From: Val Knight [REDACTED]
Sent: 02 March 2020 16:07
To: Zac Denton <Zac.Denton@arun.gov.uk>
Subject: Fw: Planning Consultation on: K/6/20/HH

APPLICATION NO: K/6/20/HH

Site Address: Flint Barn Peak Lane Kingston BN16 1RN

Description of Works: First floor rear extension, conversion of roofspace to habitable use.
Part two storey part single storey front extension and demolition of
existing conservatory and adjustments to flat roof dormer to north
elevation on existing dormer to incorporate pitched roof.

Client	
Mr K P & Mrs V L Eaton	
Project	
PROPOSED EXTENSION TO FLINT BARN, PEAK LANE, KINGSTON GORSE, WEST SUSSEX, BN16 1RN	
Title	
PROPOSED SECTION	
Drawing Status	
PLANNING APPROVAL	
Drawn	Checked
KPE	
Scale	
1:50 @ A3	
Date	
31 Jan 2020	
Job No	
20/01	
Drawing Number	
2020/Jan/Plan. 004

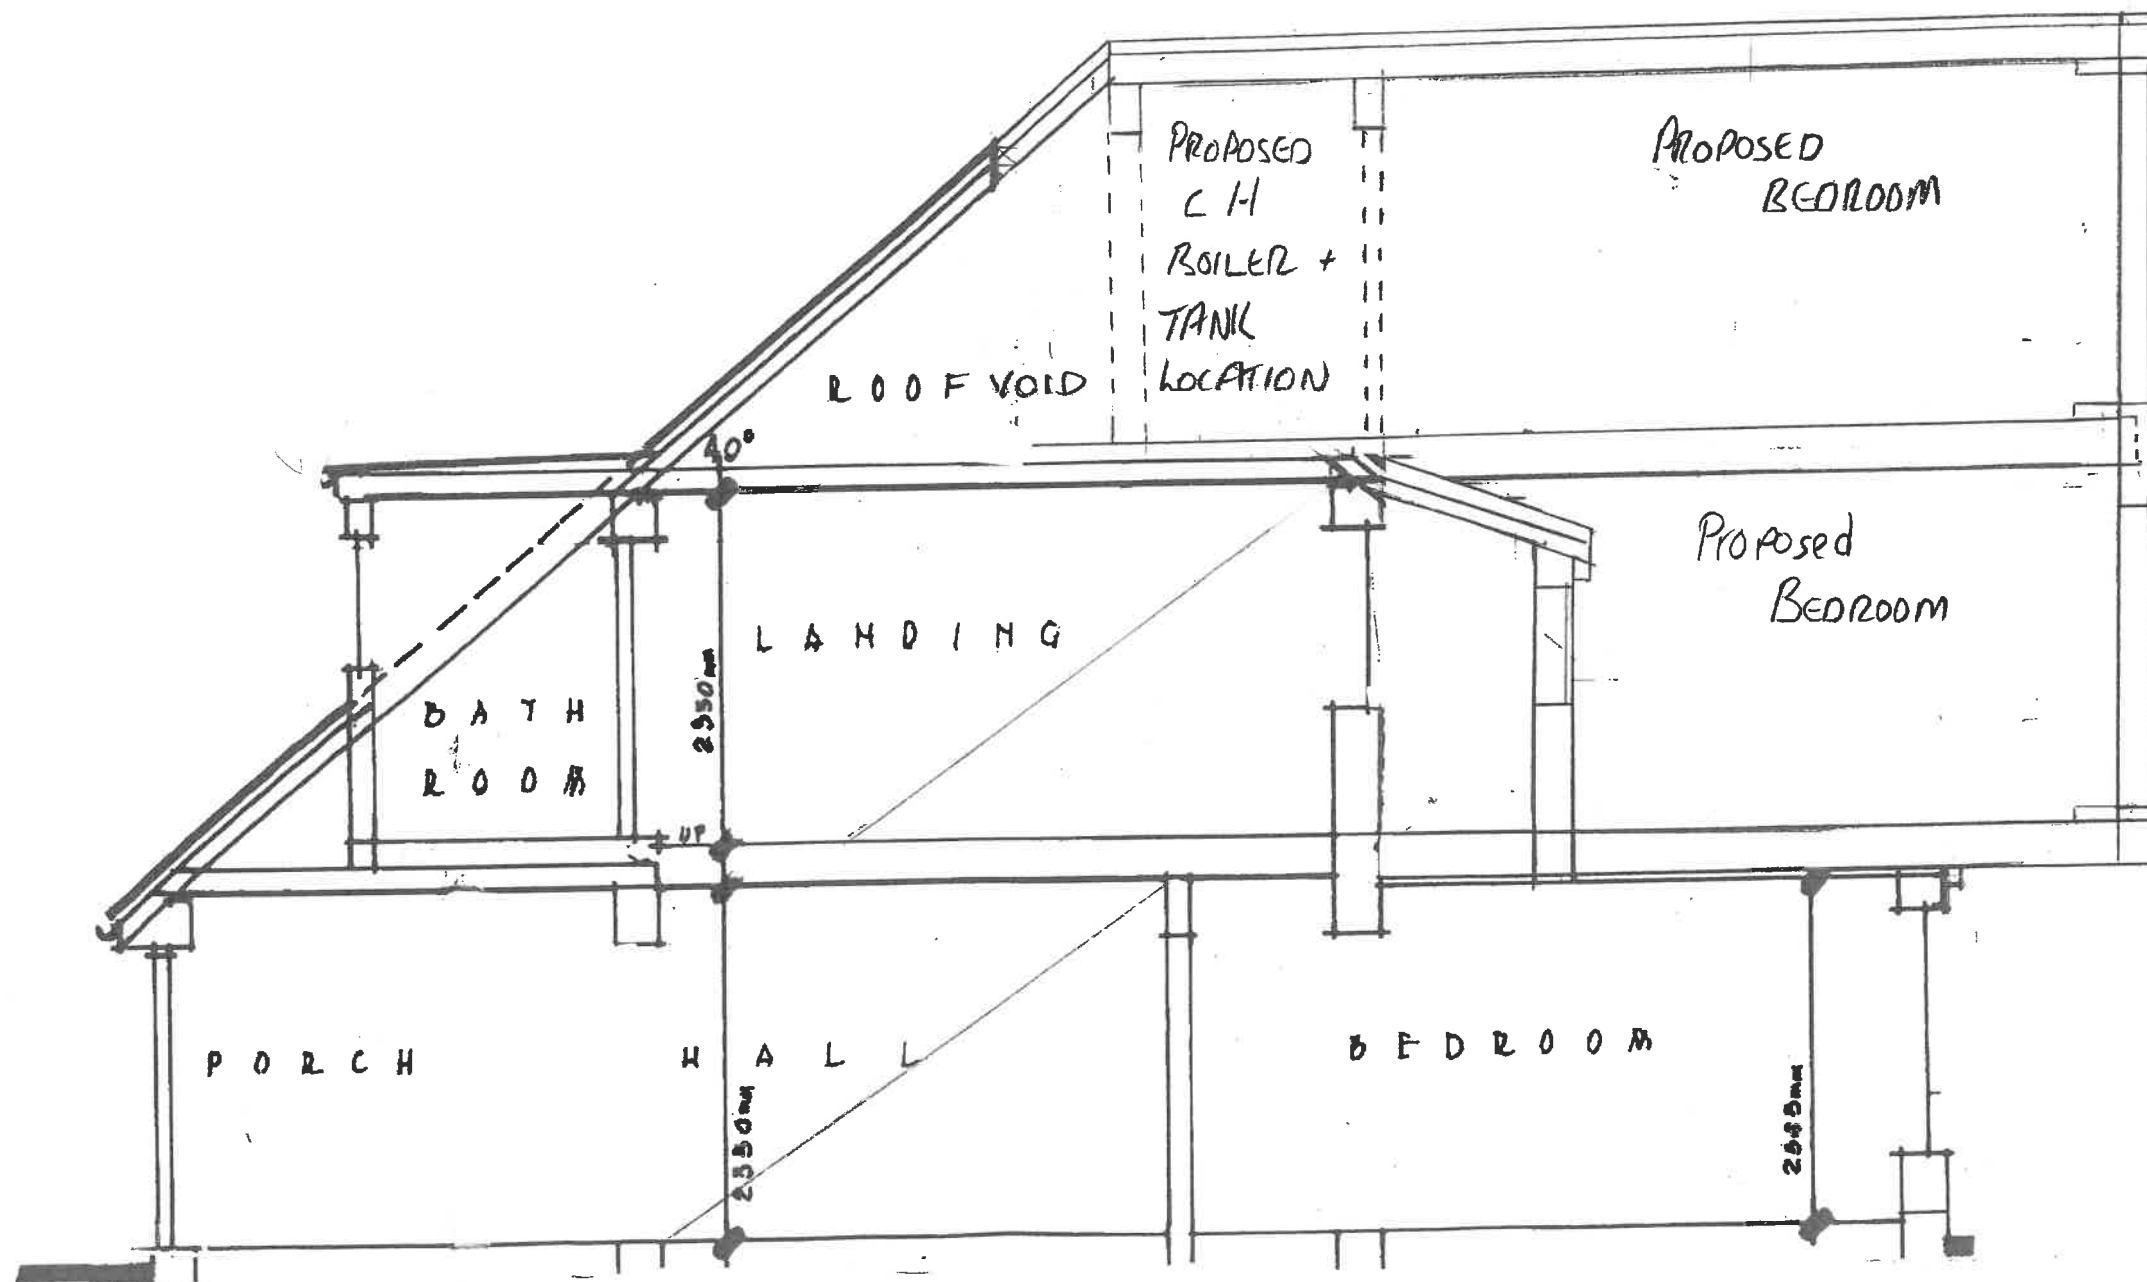
- lack of measurements for comparison
- no indication on the application that there is a change in roof height. No measurements. No comparison with roof height of nearby properties.
- no details of materials to be used. Will they match existing? Will they be sustainable?
- location plan - no measurements
- the description of the application does not make it clear this will become a three story property.
